Re: Planning Application 19/0278

Address: Land adj Lower Cock Hill Barn Hothersall Lane Ribchester PR3
2XB

Description: Change of use of land for horses, construction of new vehicular
access, stables and hard standing.

Proposed Site Plan

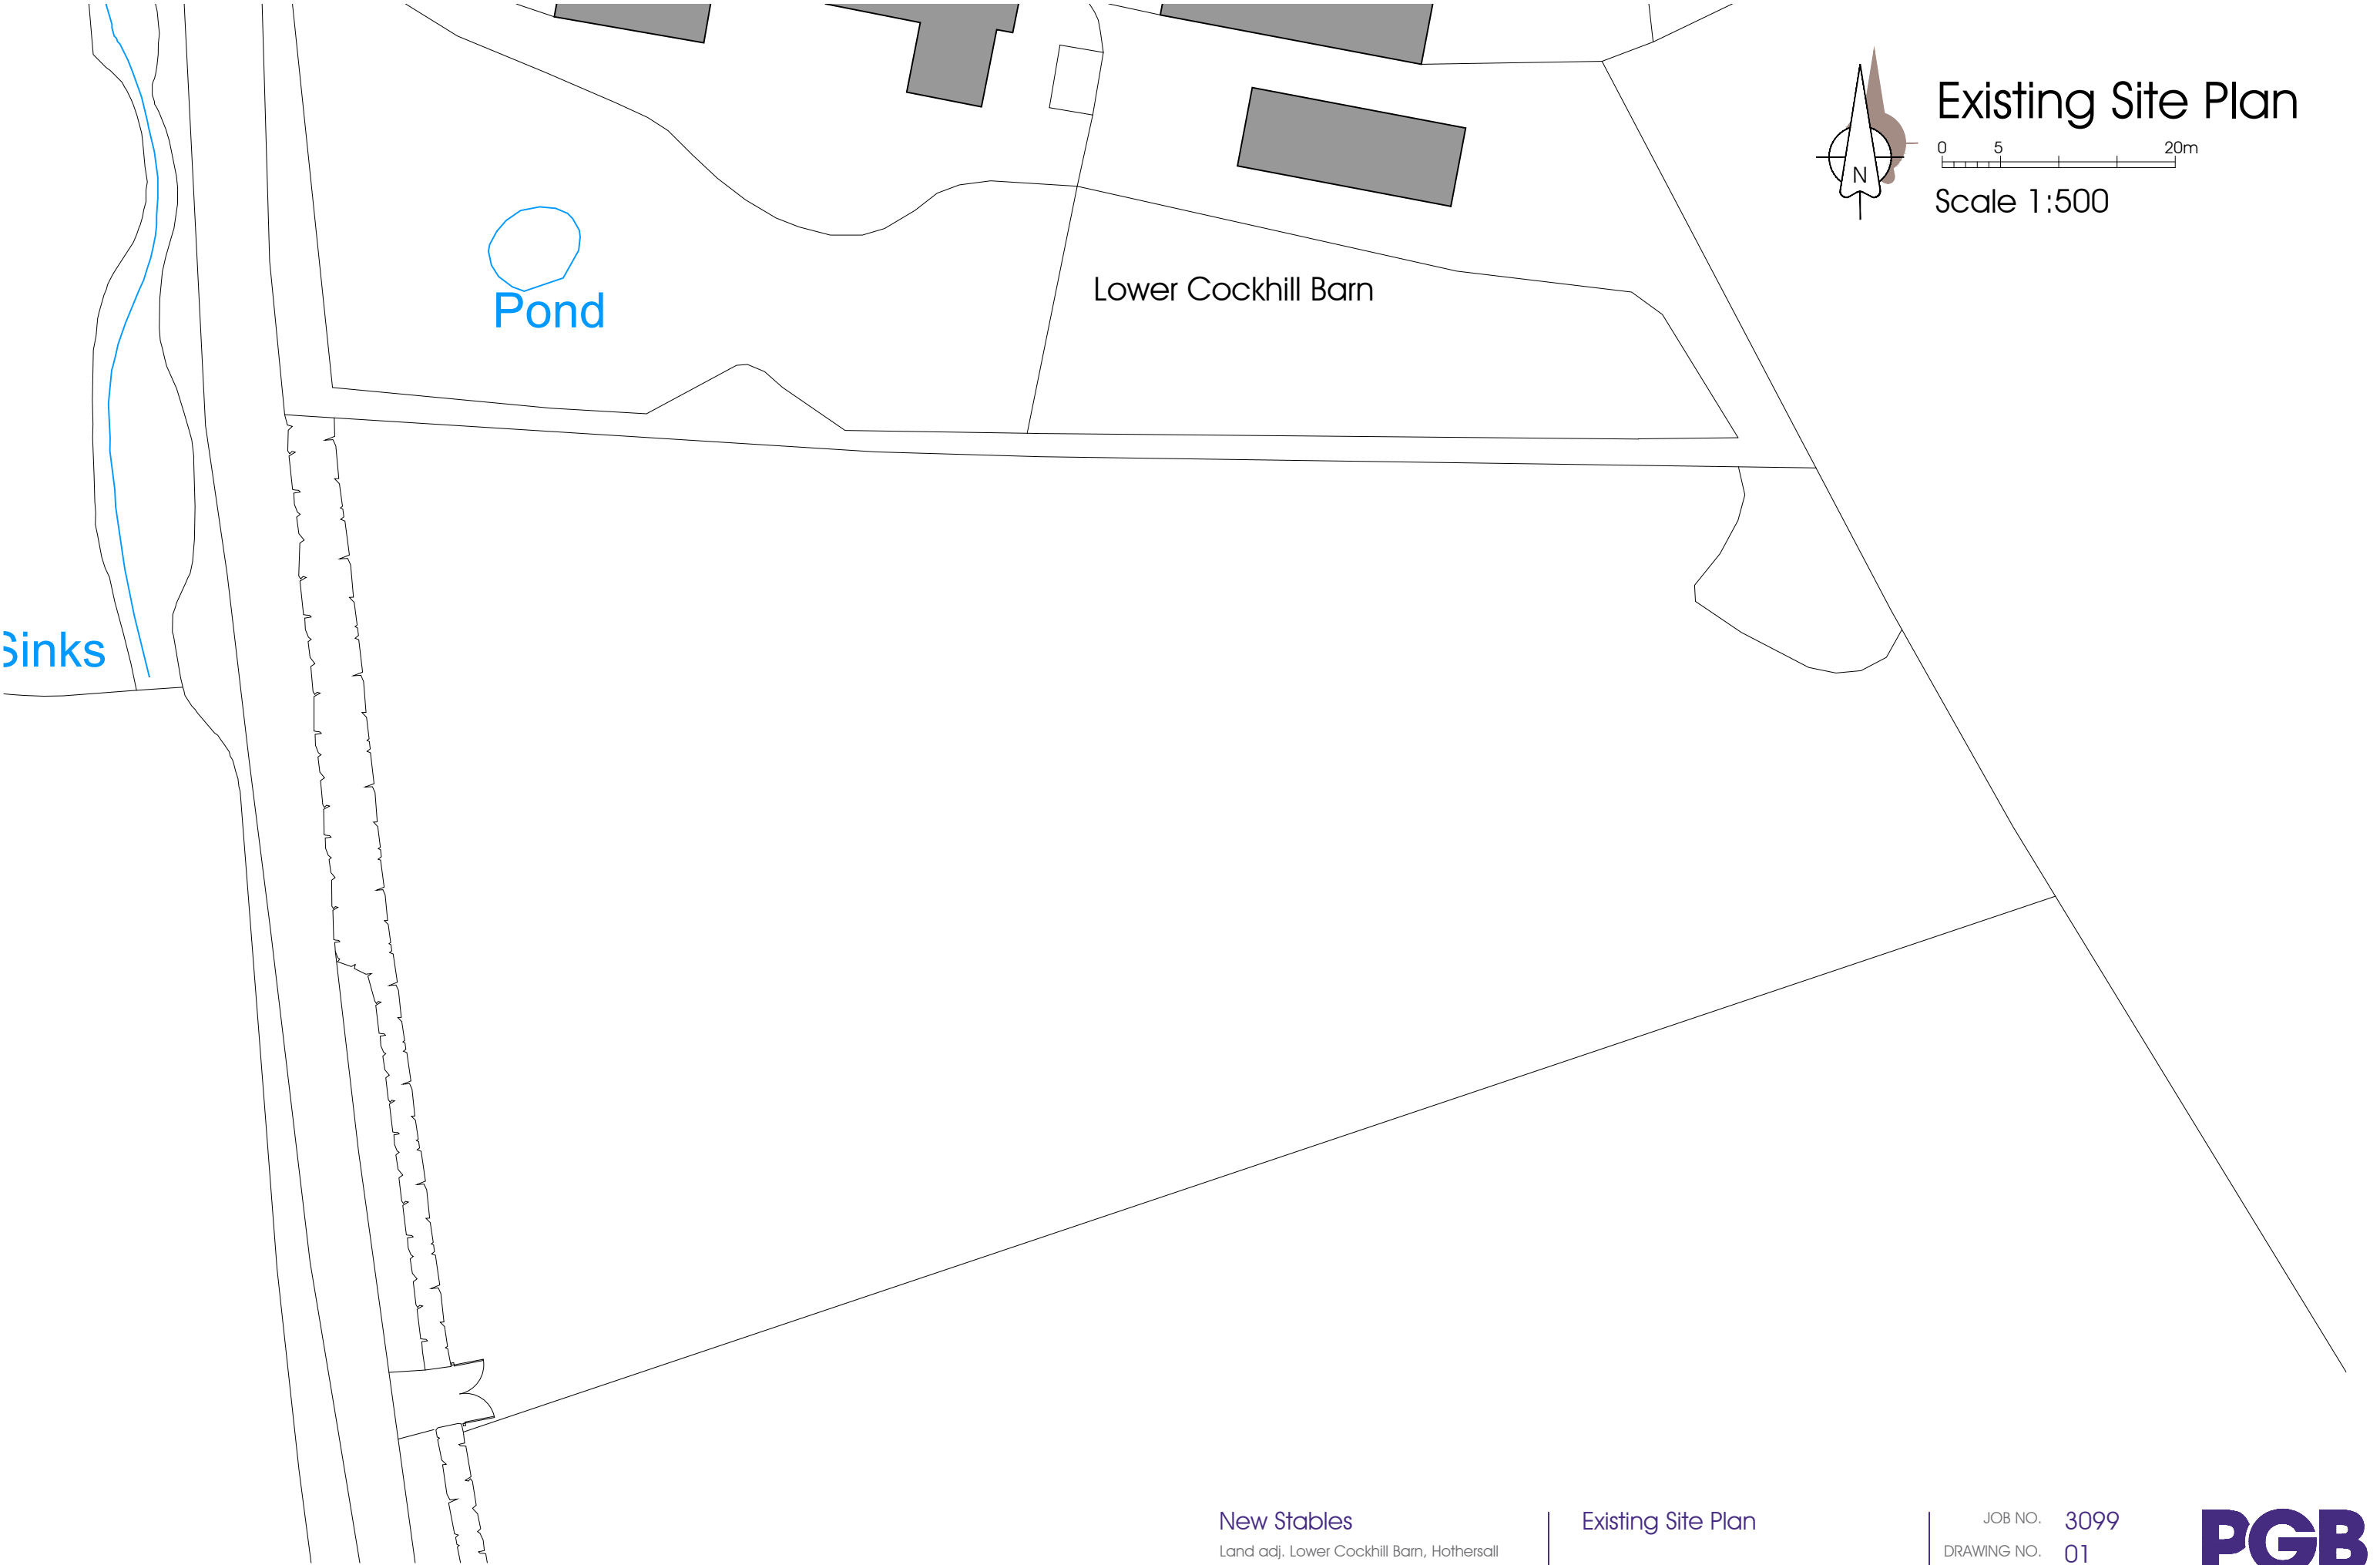
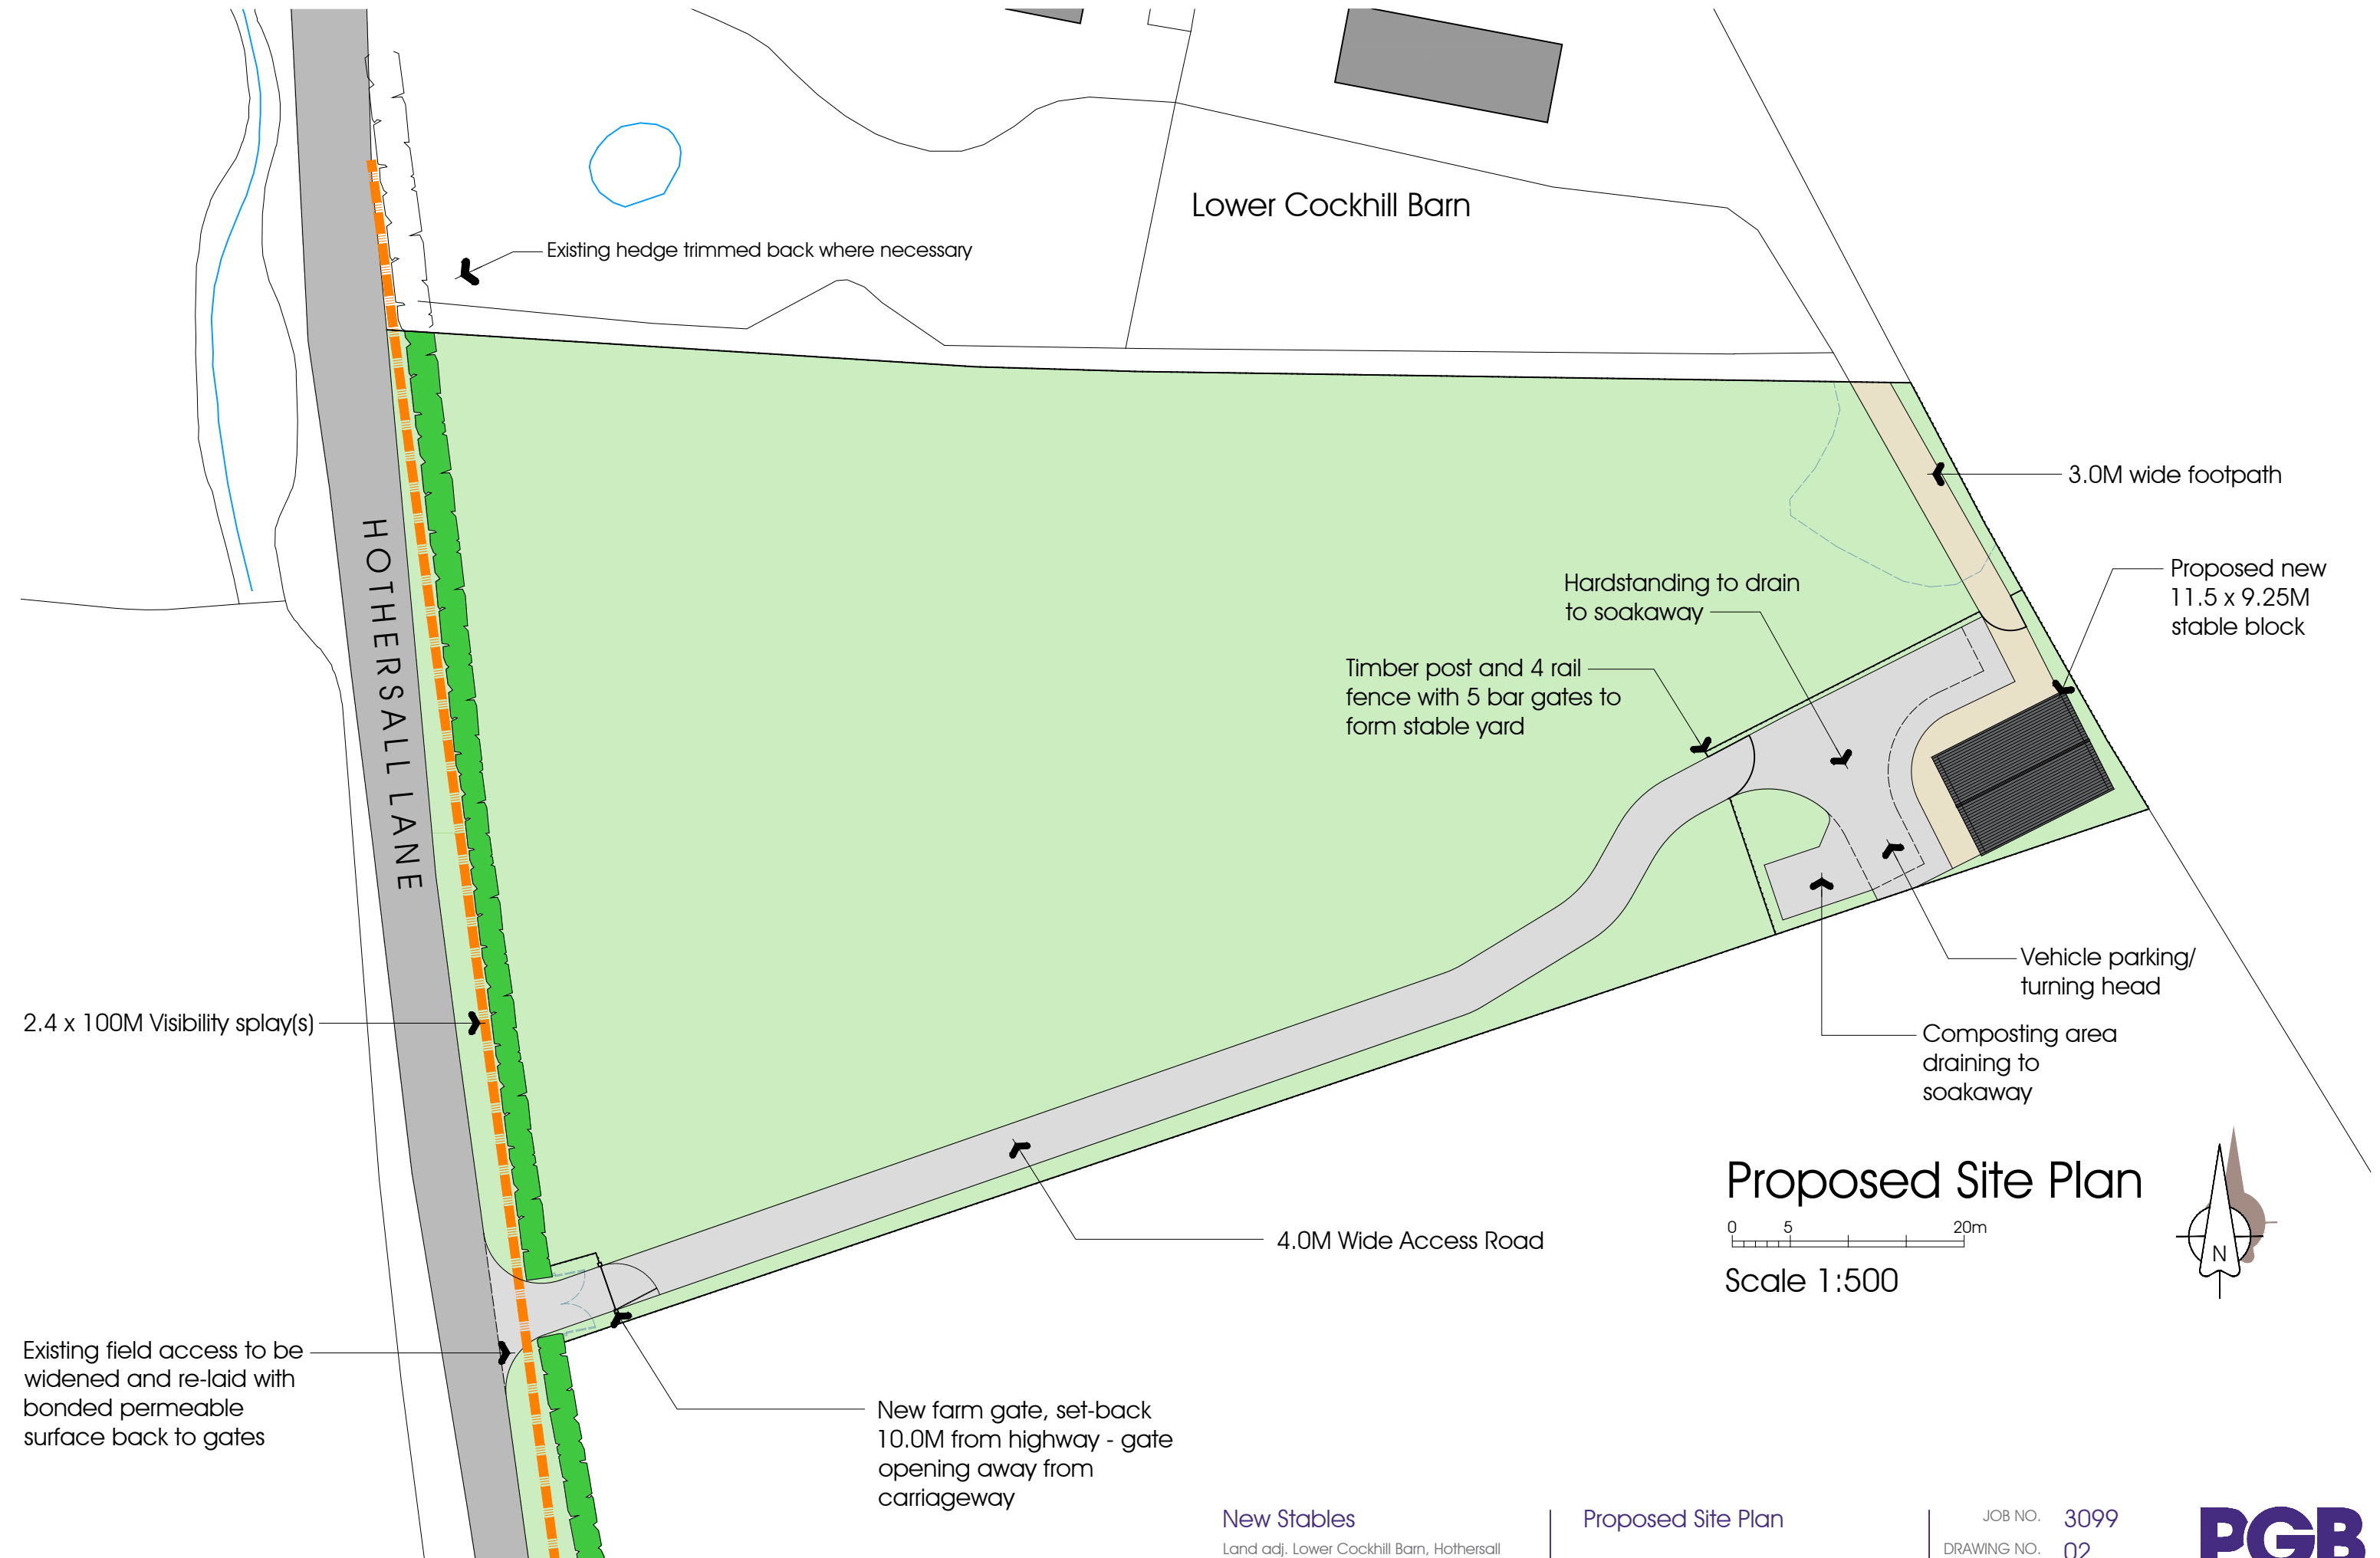
With respect to this application we would require further details regarding the access, the stables and the extent of the hardstanding, to enable us to make an informed decision.
